Our Case Number: ABP-318093-23

Re: Proposed road development at The Quay, Quay Street, Suir Island and Raheen Road
The Quay, Quay Street, Suir Island and Raheen Road, Clonmel County Tipperary

**Report on Proposed footbridge at Suir Island Clonmel
(aka Suir Island Infrastructure Links project)**

Reference: HA92.318093 (Closing date for comments 18th Dec 2023 at 5.30pm)
Decision date May 2024 ABP History – Lodged 25-9-23

TIPPERARY COUNTY COUNCIL
SUIR ISLAND INFRASTRUCTURE LINKS
OPTION 01 NORTH PLAZA
PLAN & SECTION AA

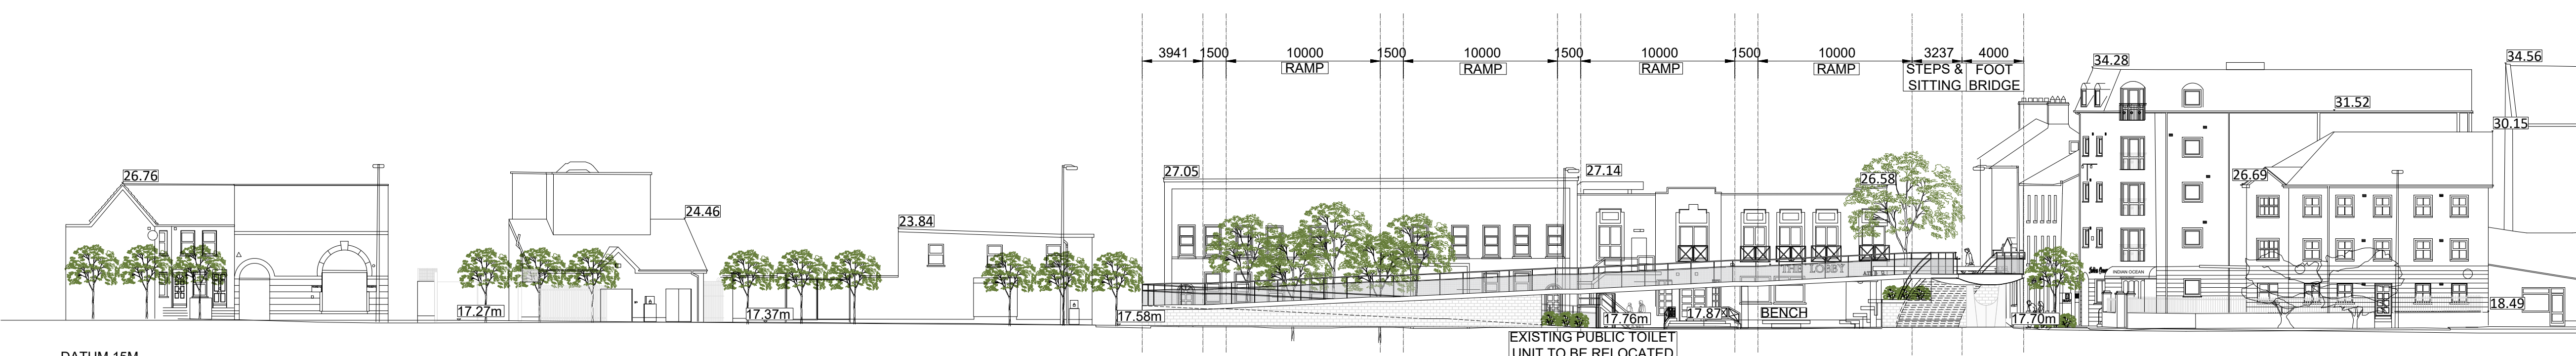
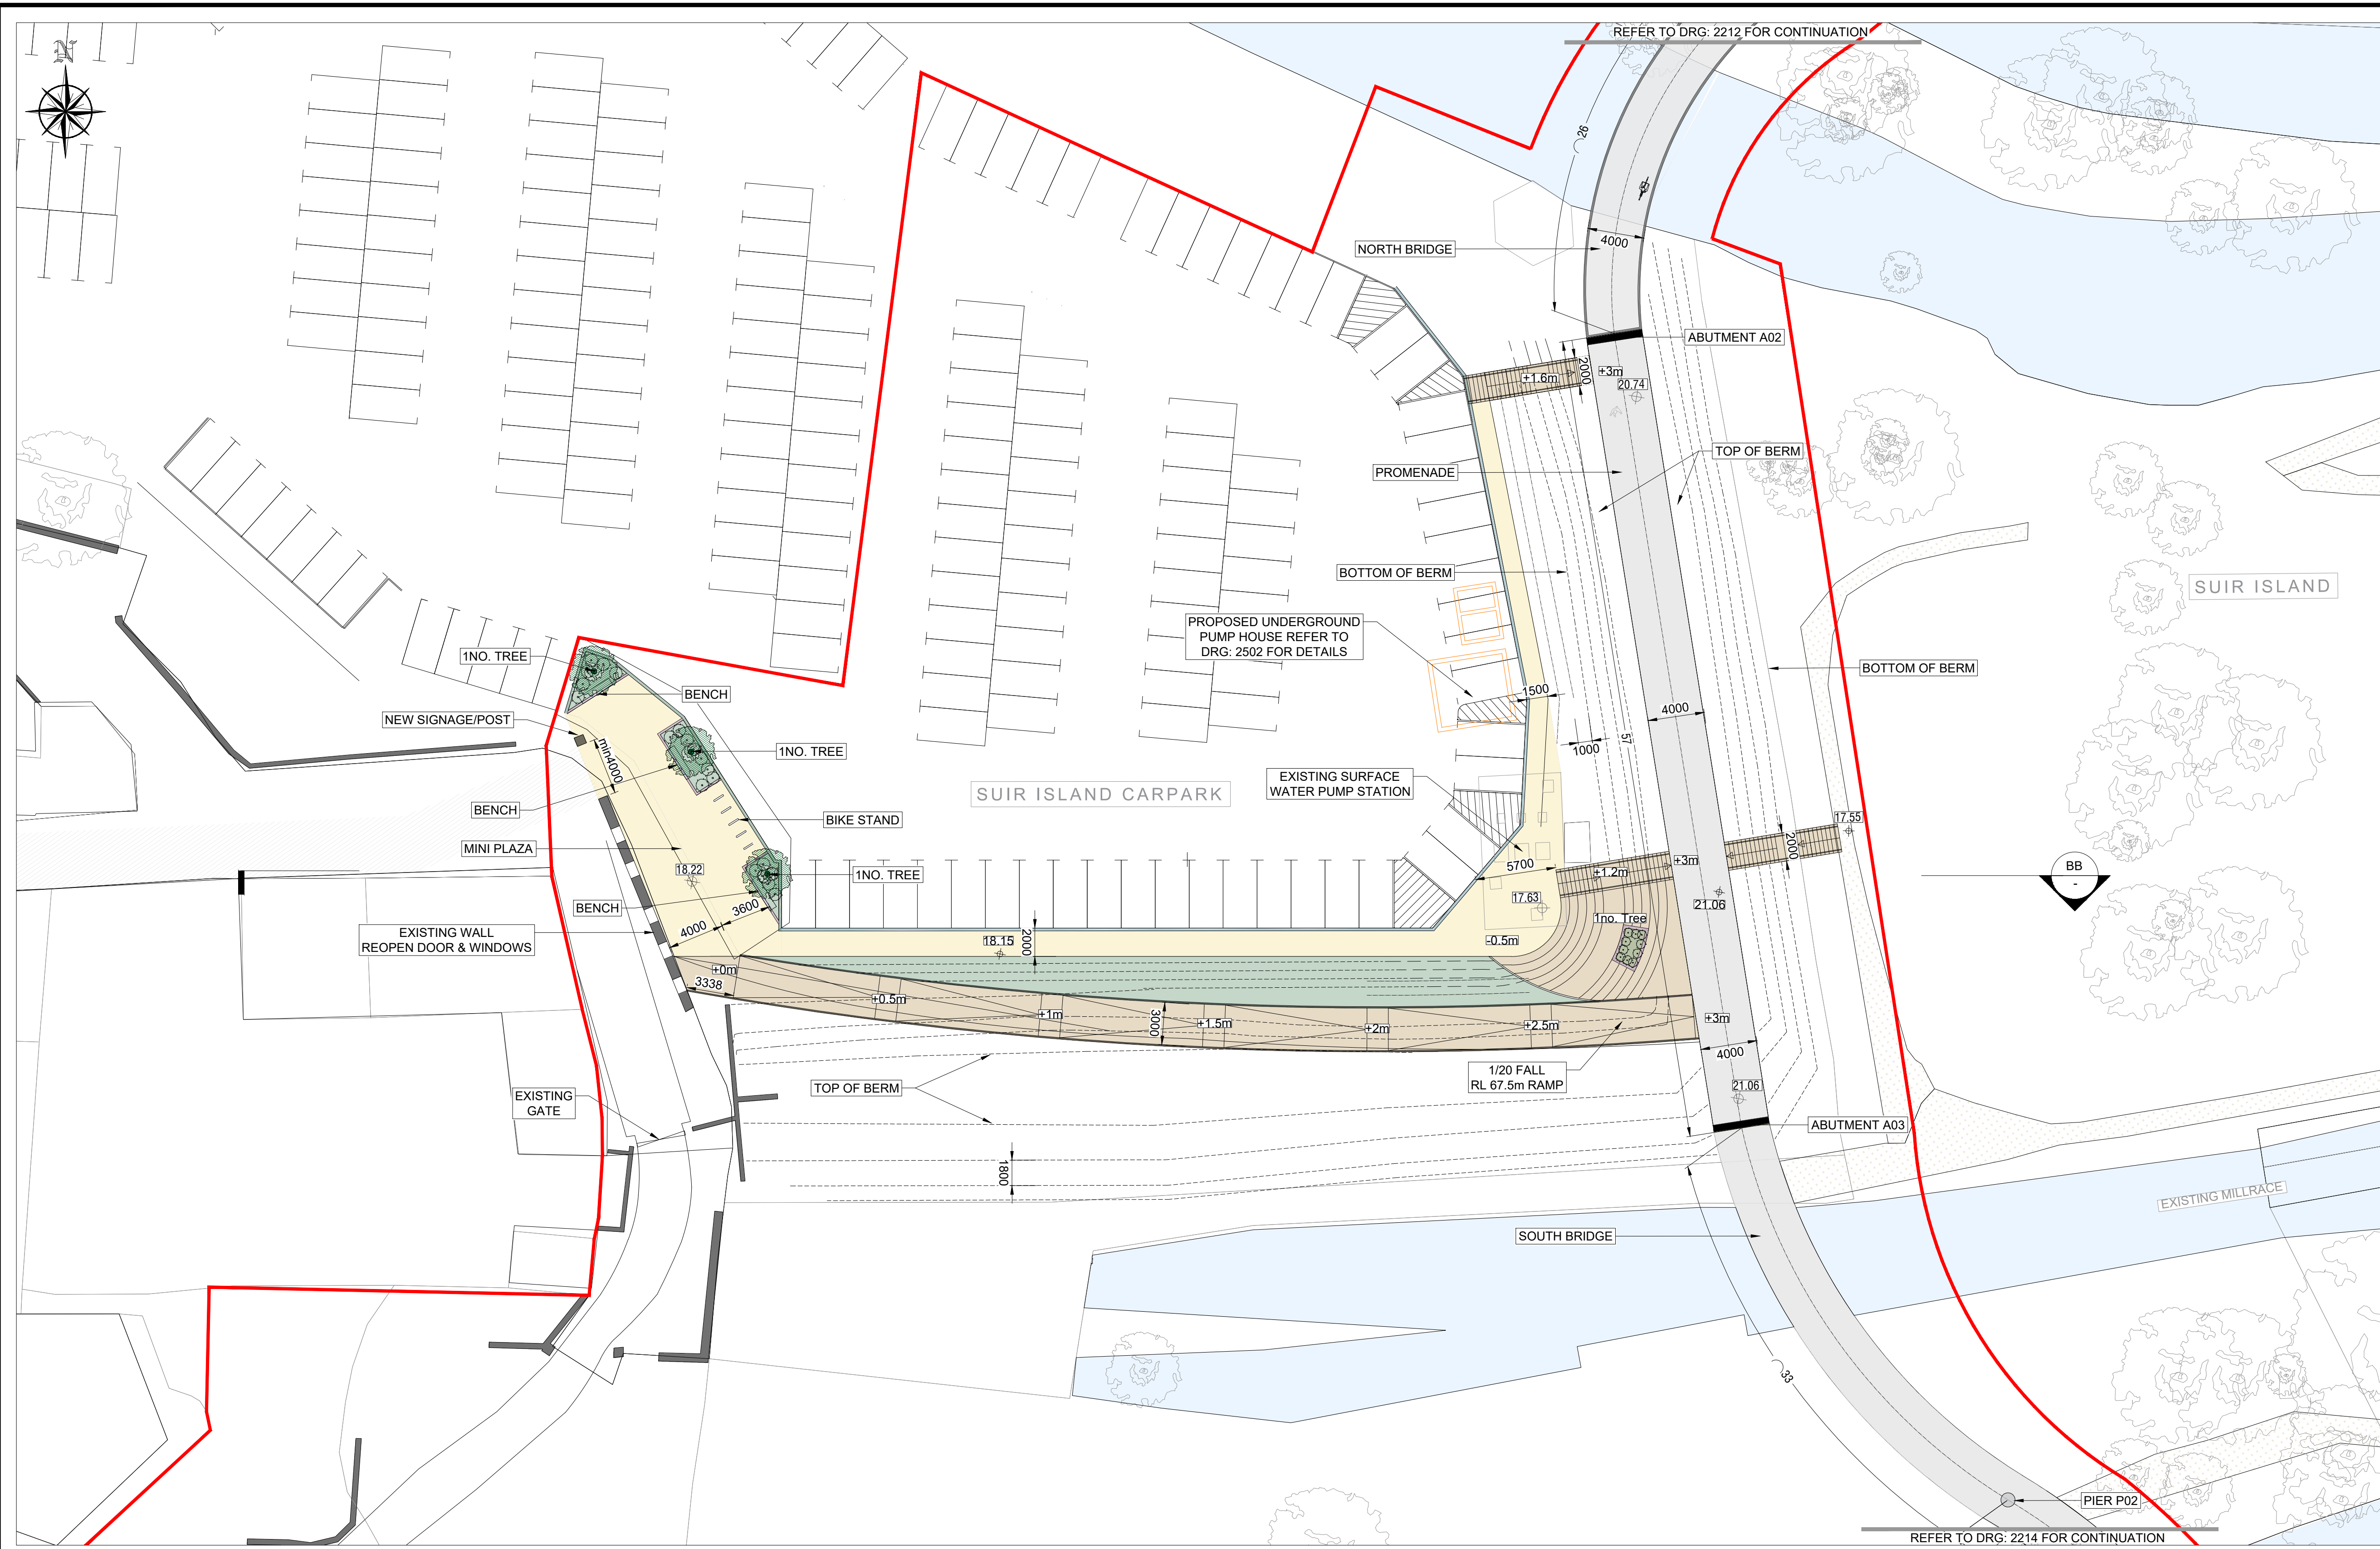
(b) The Author's main contention throughout this report is that there is no justification for the large North Plaza at the Quays in Clonmel. A more slimmed down plaza area (e.g. a set of steps and a ramp like Option 3) would have the same effect of transferring pedestrians & cyclists from the footbridge to street level and vice versa and can be designed in accordance with Part M Requirements for slope design. In terms of accessibility, the consultants have chosen Option 1 ahead of 2 other similar options. The Author asks the simple question why the northern end of the proposed footbridge needs to be so radically different from the southern end at Raheen Road given that both ends will effectively carry the same volumes of pedestrians and cyclists in future?

(c) The consultants have suggested that a new "performance" space will be created at the proposed Northern Plaza (Option 1). No reference is made to the many high quality public "performance" spaces already available in Clonmel as listed below and there are plenty of other venues in the hinterland not included. It is noteworthy that Tipperary County Council has not issued a copy of the "consultants brief" to verify if an extra "performance space" was requested. The consultants make no reference to the following list of performance spaces currently available (some like the Mainguard almost within a "stones throw"):

Based on the above listing, the Author considers there is no shortage of Performance areas around the town. It does not make sense therefore for the consultants to suggest that a new enlarged "Northern Plaza" for performance events is required as part of the footbridge. This area must retain parking & 2-way traffic in accordance with the 2013 C & EDP.

(d) According to Table 3-1 on Page 13 Chapter 3 of EIAR, approximately €4 million of the overall €13million project costs will be required to construct the North Plaza element of Option 1. A more modest landing area with some parking retained could be constructed for perhaps ¼ of this amount i.e. €1 million in the Author's opinion and thereby save €3million for other improvement works within Suir Island area itself subject to permission & funding being in place. It appears that Tipperary County Council has not assessed the value for money aspects of the proposed North Plaza in comparison to other elements of the project. Instead they have proceeded immediately into a Public display of the latest proposals following the ABP decision to seek an EIAR. While the Author understands that ABP may not be concerned about project costs, nevertheless it is an important consideration to seek value for money and seek the best possible presentation of Suir Island's assets in the public interest.
